NSW RURAL FIRE SERVICE

Your reference: SSD 7419
Our reference: D16/2436

Modification to proposed new habitat and eco-tourist facility at Taronga Zoo Bradleys Head Road Mosman

Drawing Title
POD B ELEVATIONS

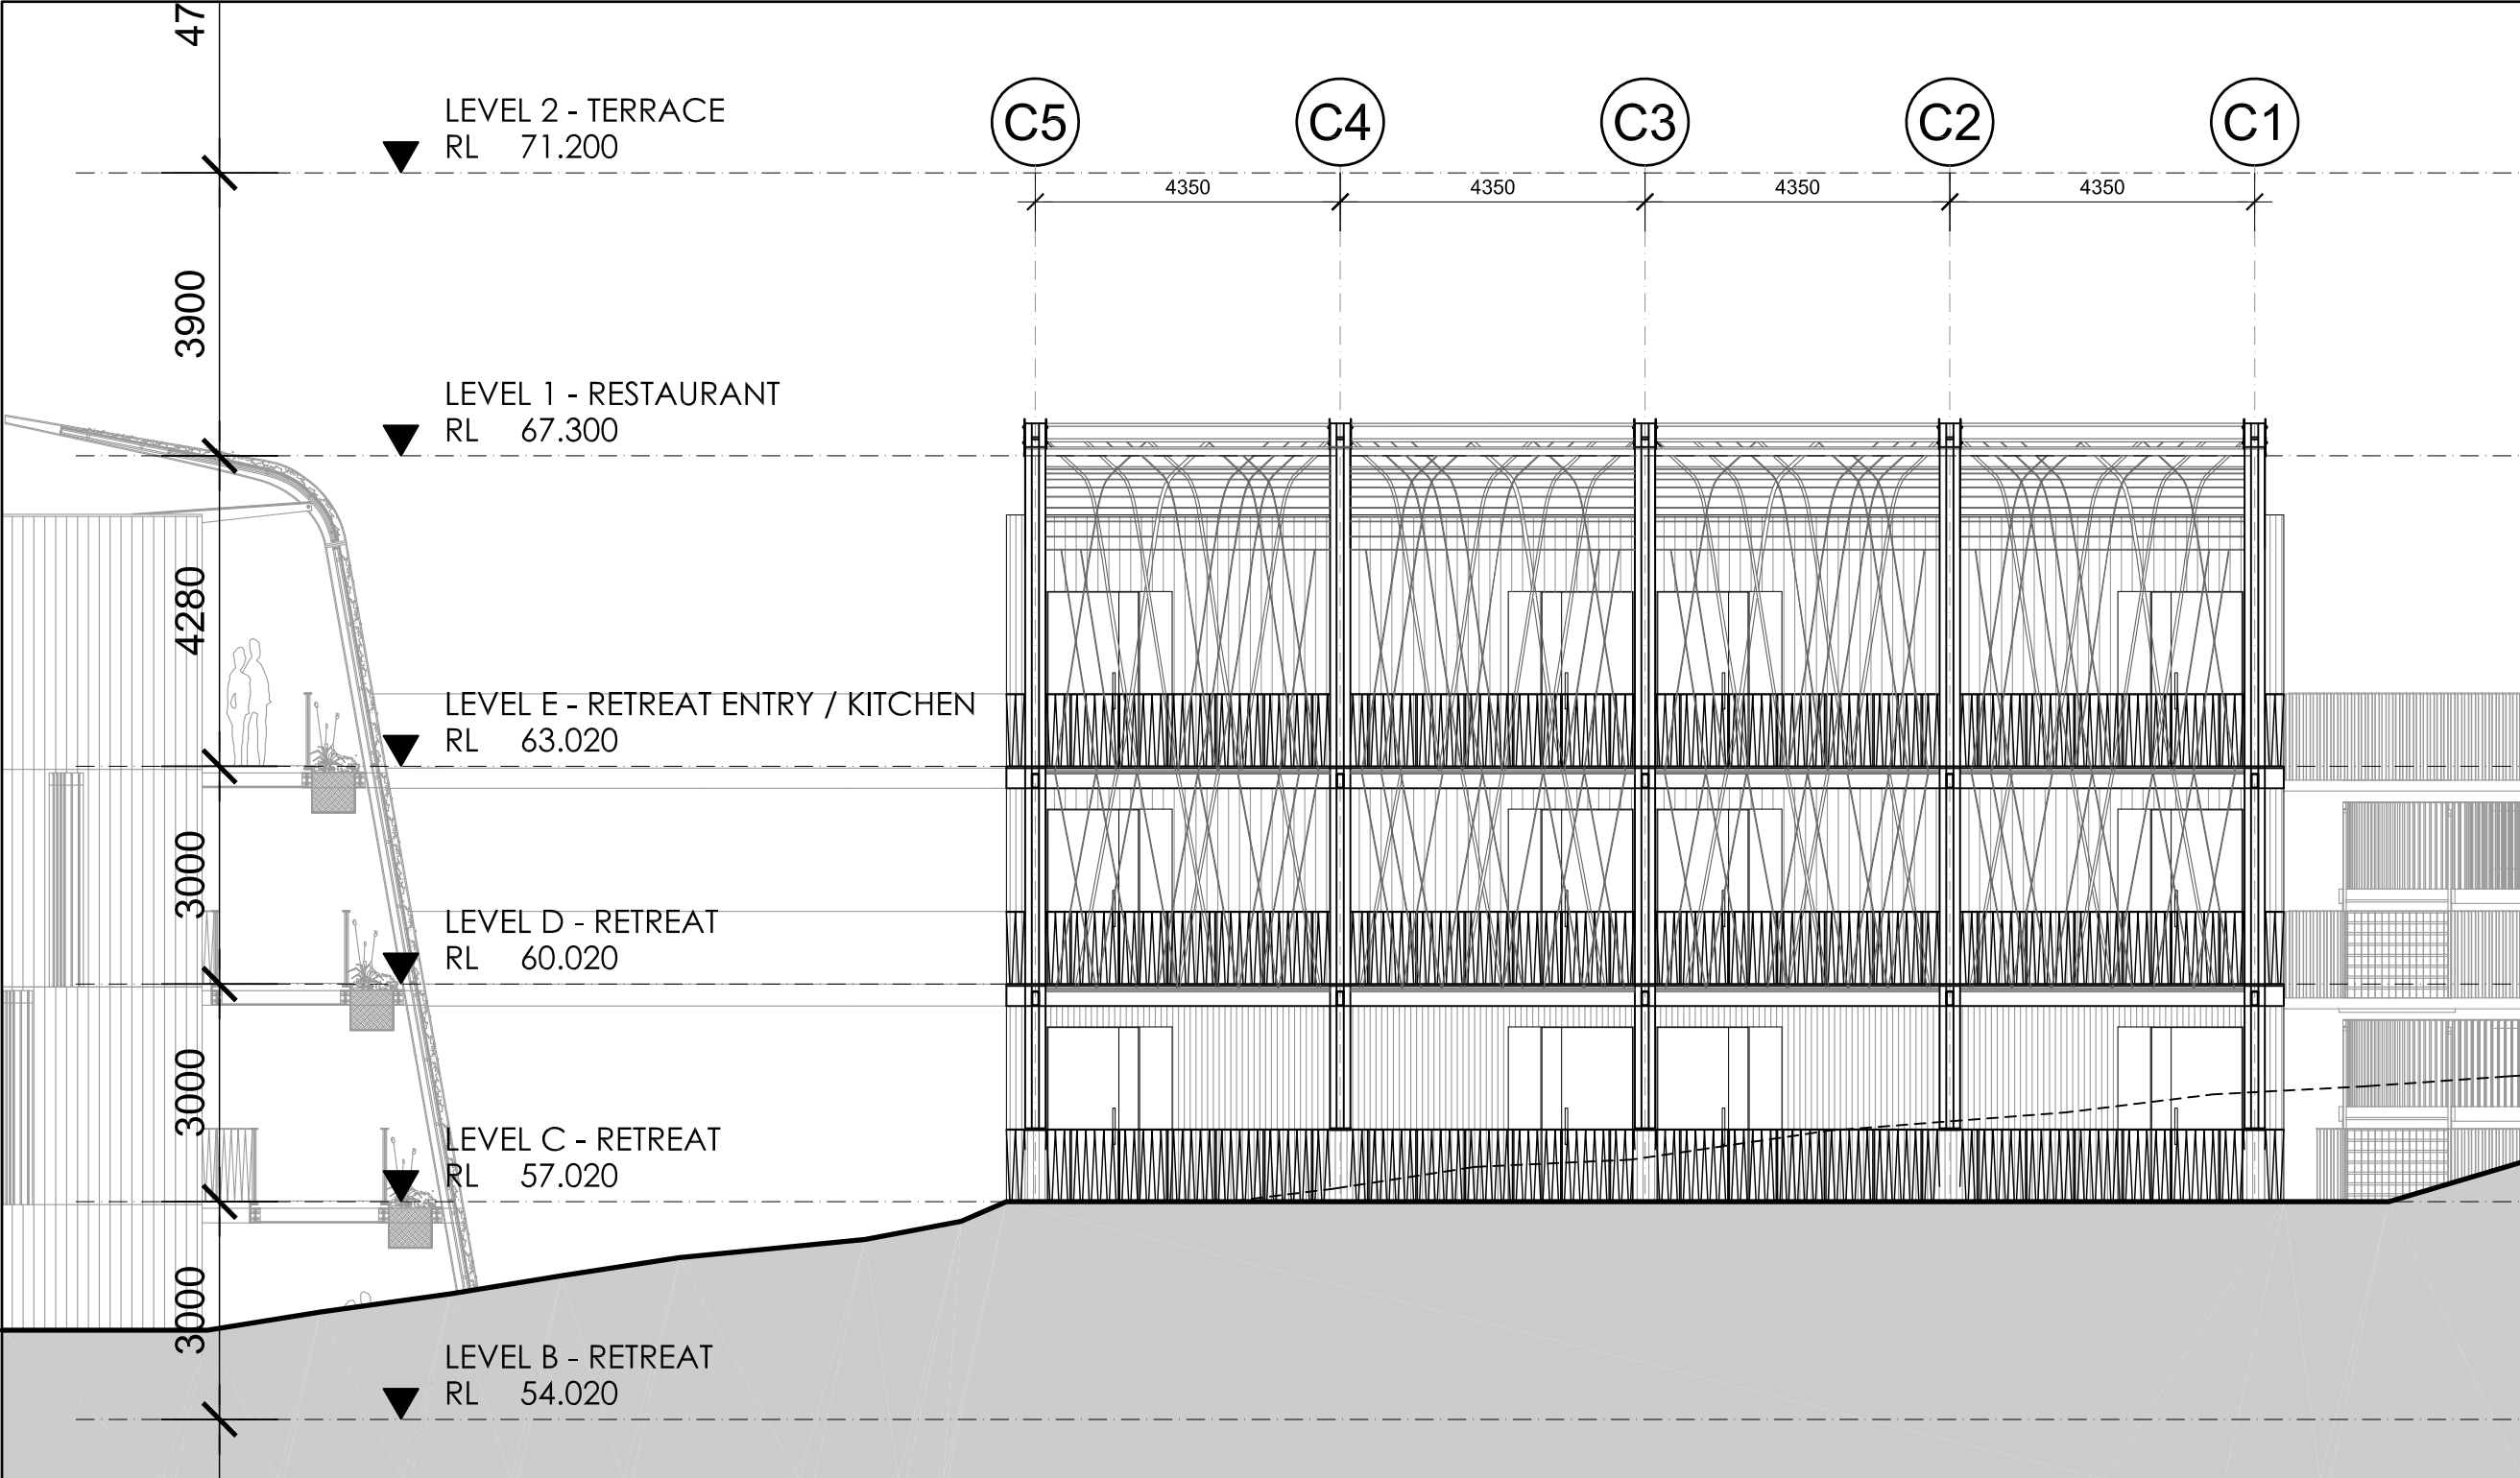
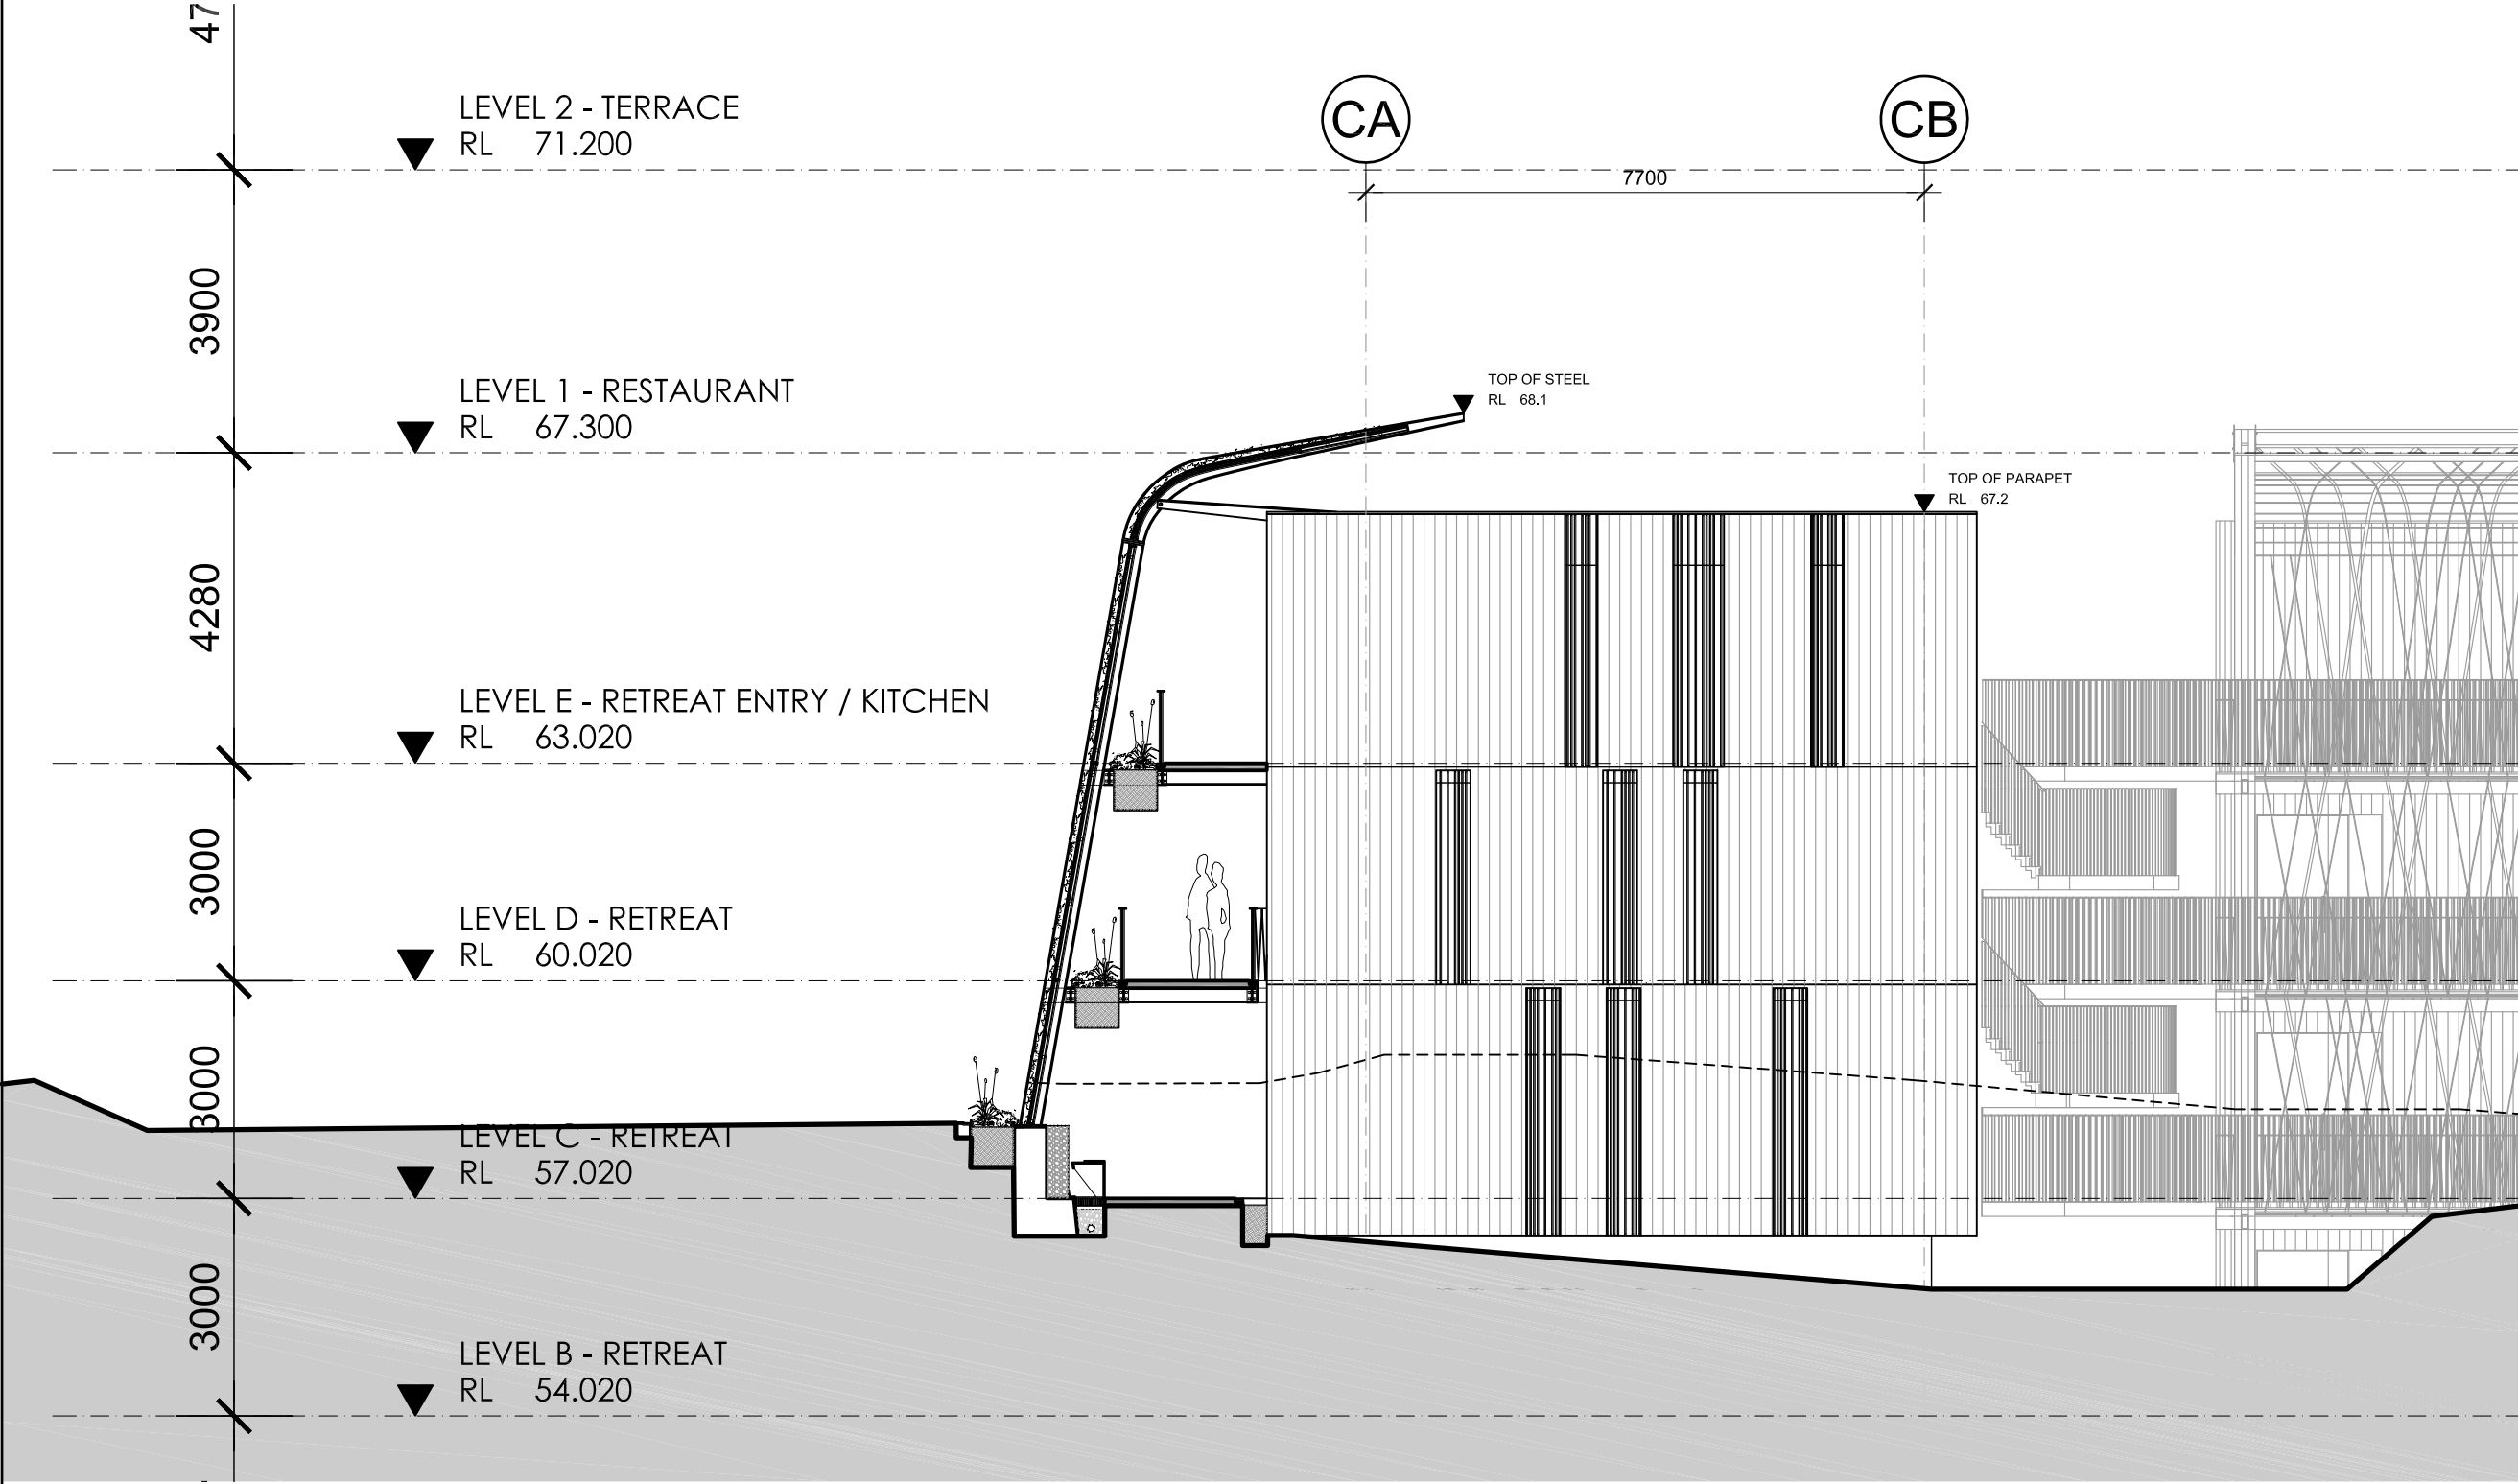
automated sprinkler system can be considered for the southern façade of Pod D given the management of vegetation on site. The external northern and eastern facades of Pod B do not require these sprinklers based on the BALs.
